Huntingwood Processing Facility Expansion (SSD-17352813)
Additional Matters for Submissions Report

ATTACHMENT 1

Based upon the Department's review of the information of the EIS, the Department considers further information is required to clarify matters and addresses inconsistencies within the documentation. In this regard the following information is required to be provided:

Figure 16 Vehicle access points

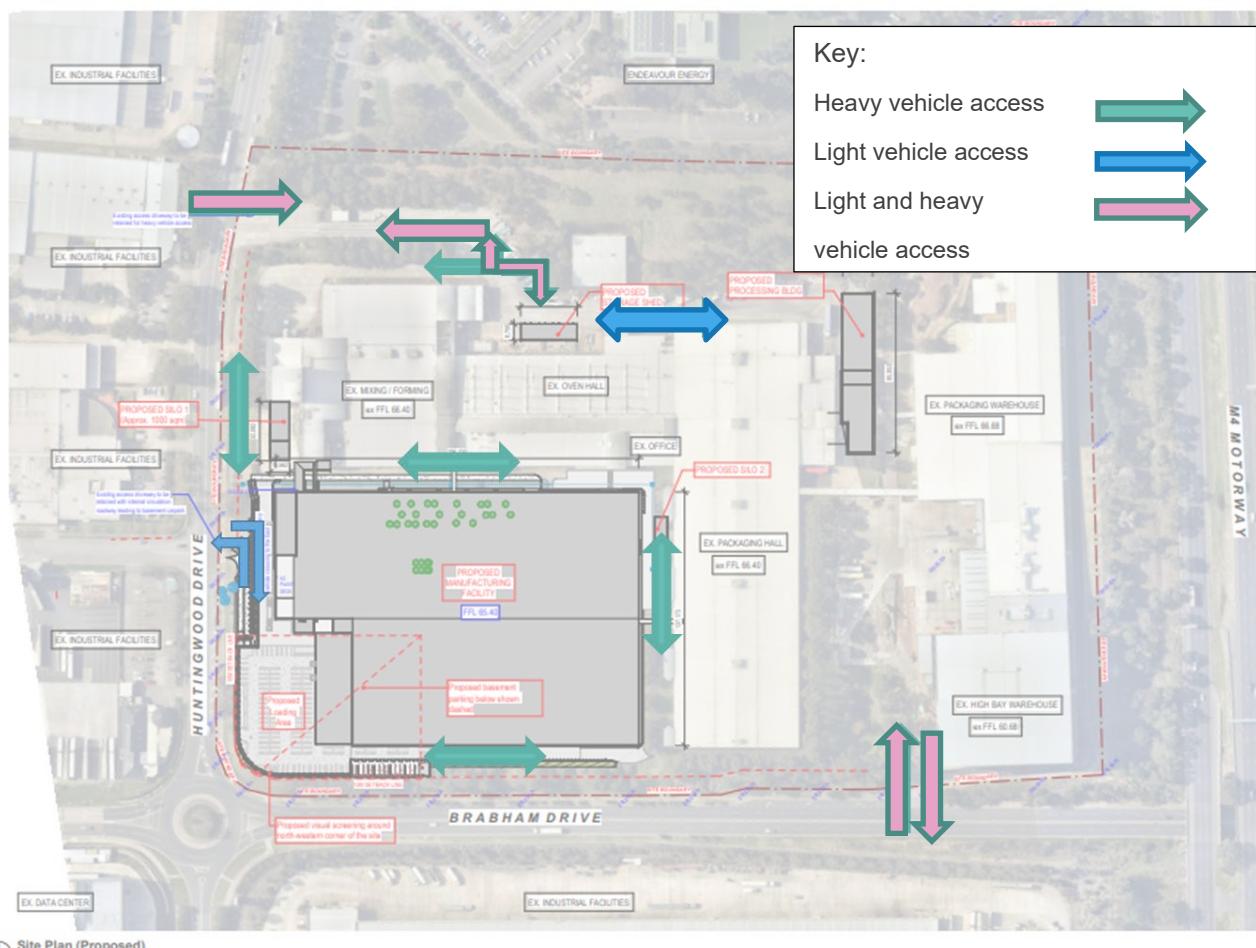
2. Confirm the unloading locations for the existing and proposed silo buildings and the new smaller processing building. If the unloading locations are located in areas utilised for through traffic movements, it will need to be explained how the interaction between parked and transiting heavy vehicles will operate in practice.
3. Table 11 (TIA) – Total vehicle entries and exits for Huntingwood 1 are not equal. Huntingwood 2 is movements are equal.
4. In accordance with the submission made by Transport for NSW, the intersection performance of Brabham Drive and Great Western Highway shall be assessed.
